Consultation Response from: KC Environmental Health (Pollution & Noise Control)

2024/92938 - 1st, 2nd and 3rd Floors, 1 Lord Street, Huddersfield, HD1 1QA

Prior notification for change of use from Class E (commercial/business/service) to 9 residential apartments (within a Conservation Area)

**Responding Date:
07 November 2024**

Proposed Ground Floor Plan
1:100

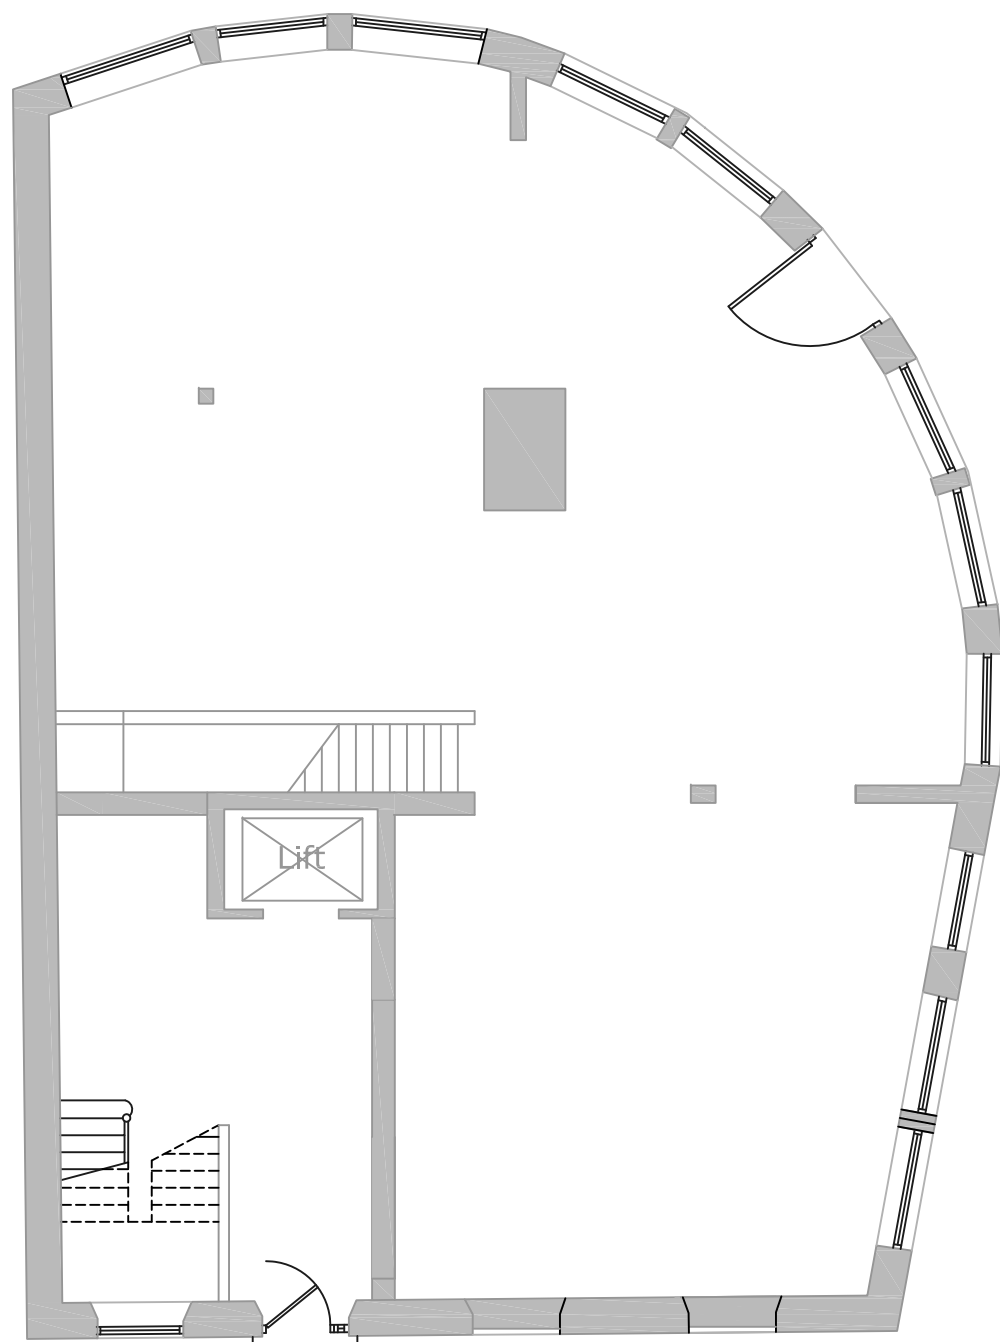
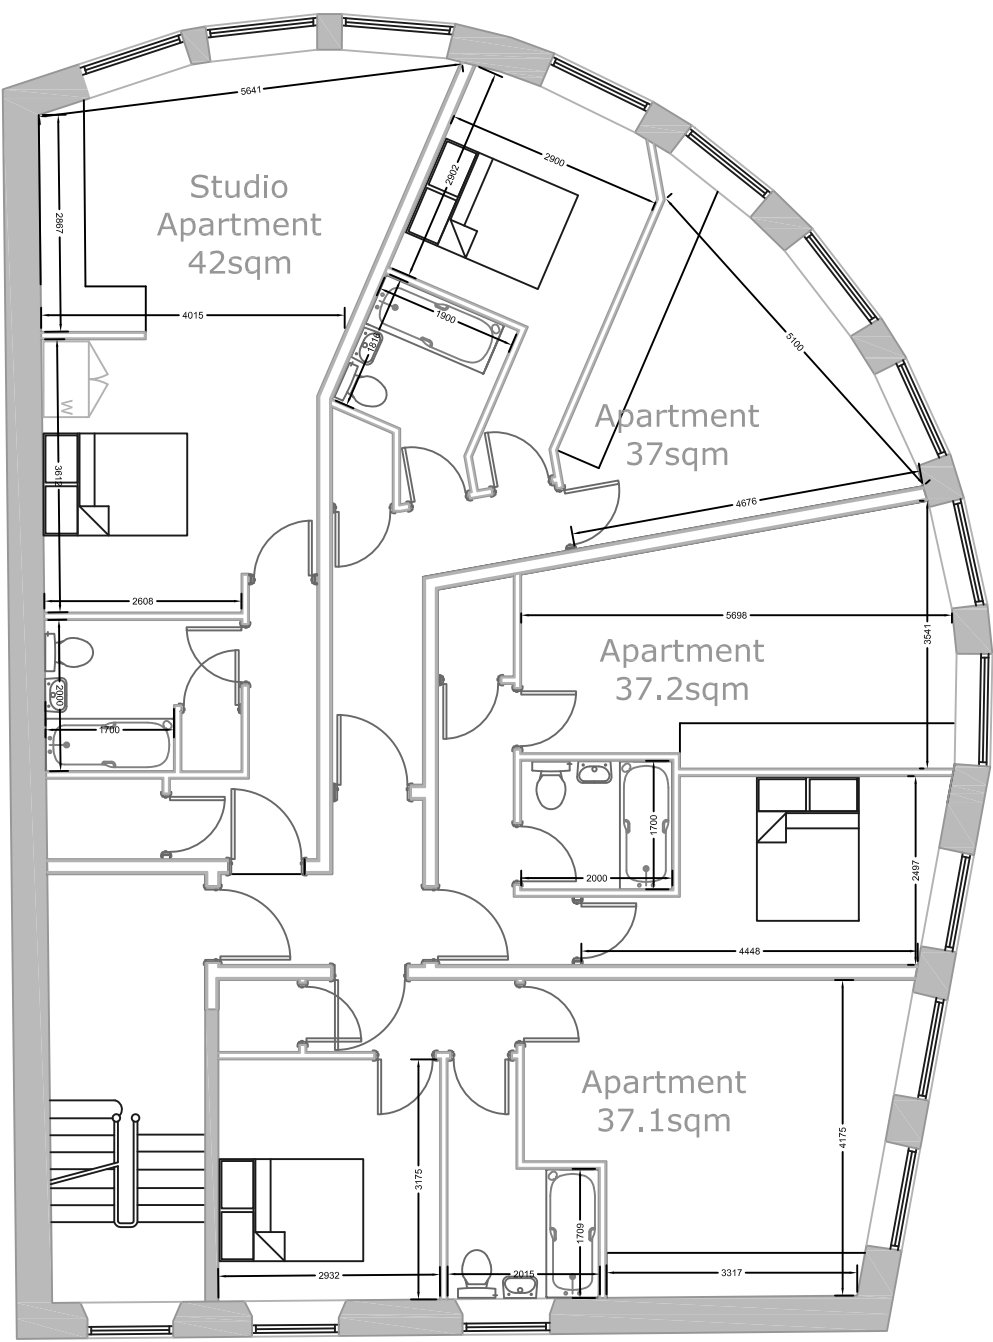
The applicant has submitted an Environmental Noise Survey authored by soundtesting dated 23 January 2018 ref 10104E Rev 1. It considers the external sources of noise but fails to consider the commercial use of the ground floor with particular reference to the transmission of noise. The applicant is hereby informed that a higher level of sound insulation is required where commercial and residential uses share a party wall/floor/ceiling. Our requirement is a minimum of 10dB above Buildings Regulations i.e. 53dB $D_{nTw} + C_{tr}$. We note the report is coming up to seven years old and recommend the submission of an up to date Noise Assessment to consider all sources of noise.

NC6 For use where proposed commercial and residential share a party structure (floor / ceiling or wall etc) – Condition

Before the development is brought into use written evidence to demonstrate that the airborne sound insulation performance of the party floors/walls/ceiling of the development is of a minimum of 53dB $D_{nTw} + C_{tr}$ shall be submitted to and approved in writing by the Local Planning Authority. If it cannot be demonstrated that the aforementioned airborne sound insulation performance has been achieved, a scheme incorporating further measures to achieve the
